Our ref: New High School in Bungendore (SSD-14394209)

26 October 2022

Subject: Request for Additional Information

Project Name	HIGH SCHOOL IN BUNGENDORE		
Drawn	JF	Approved	
Date	HAR 2021	Project Ref	20096 CE-SD-HS-2014
Sheet	A0	Drawing No	Rev

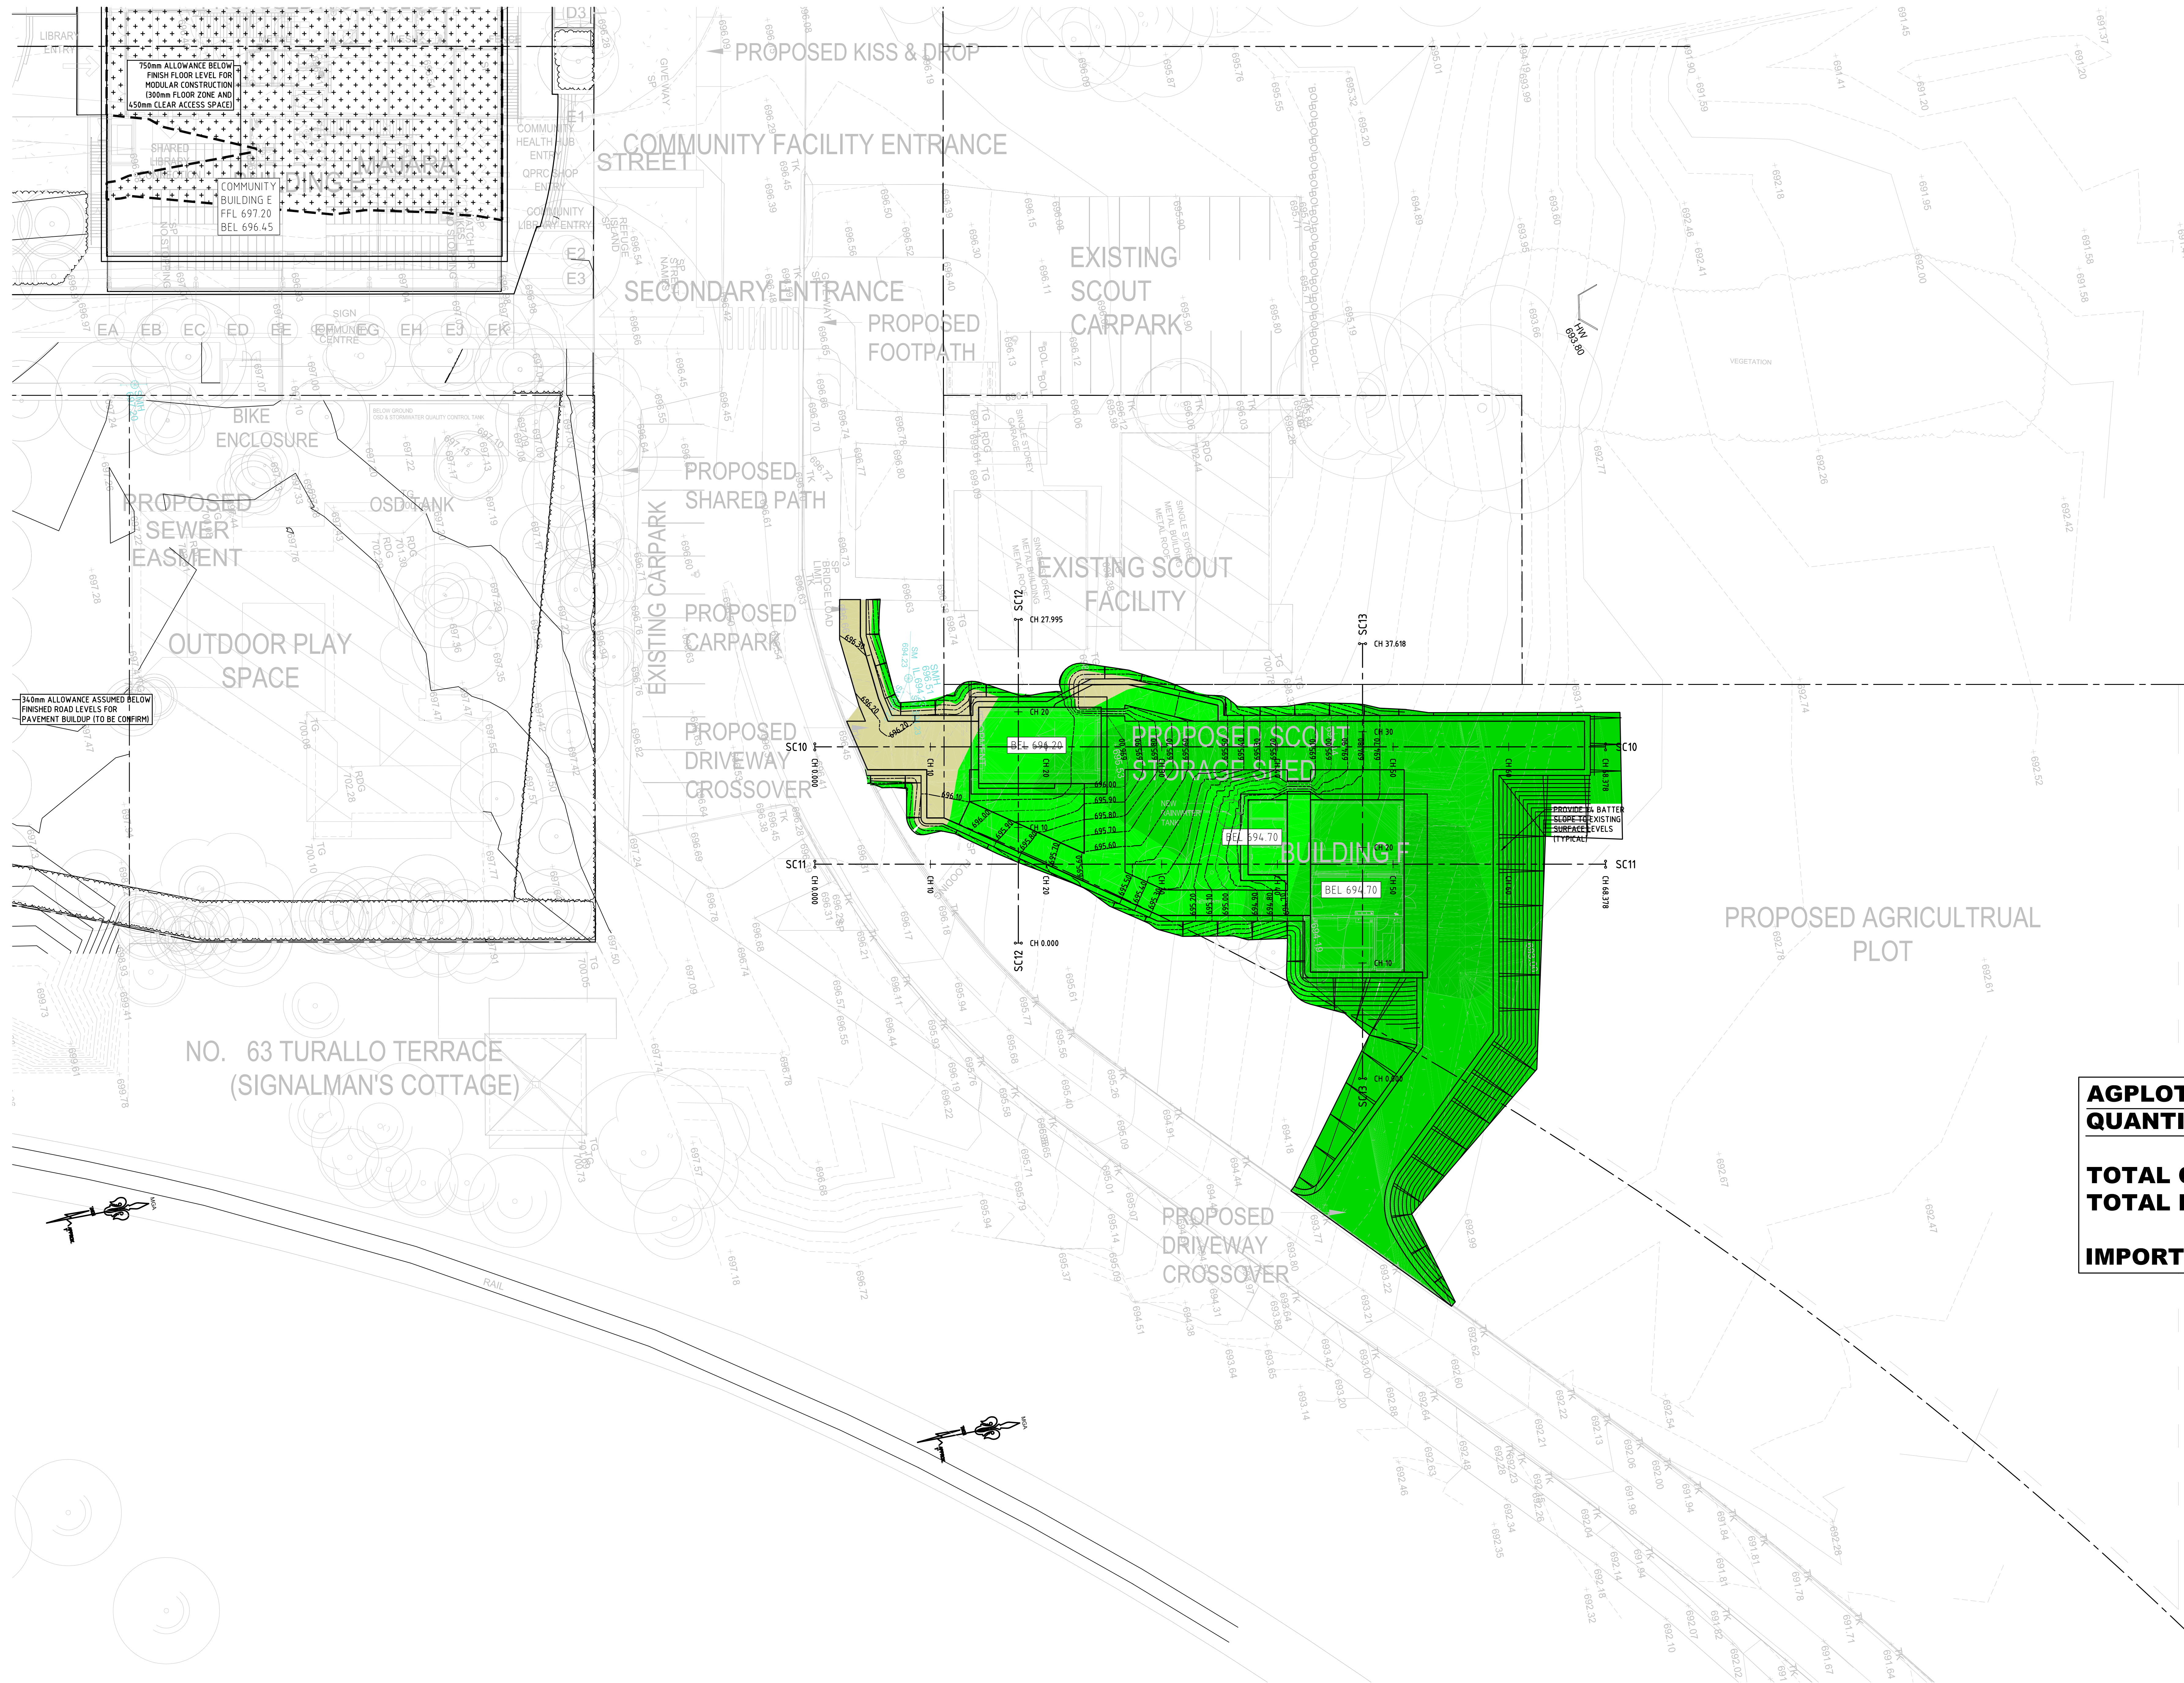
- Provide plan BHS-CE-2053 which shows on-site detention details as referenced in Plan BHS-CE-2031 and the Amendment Report, but not provided on the civil drawings.
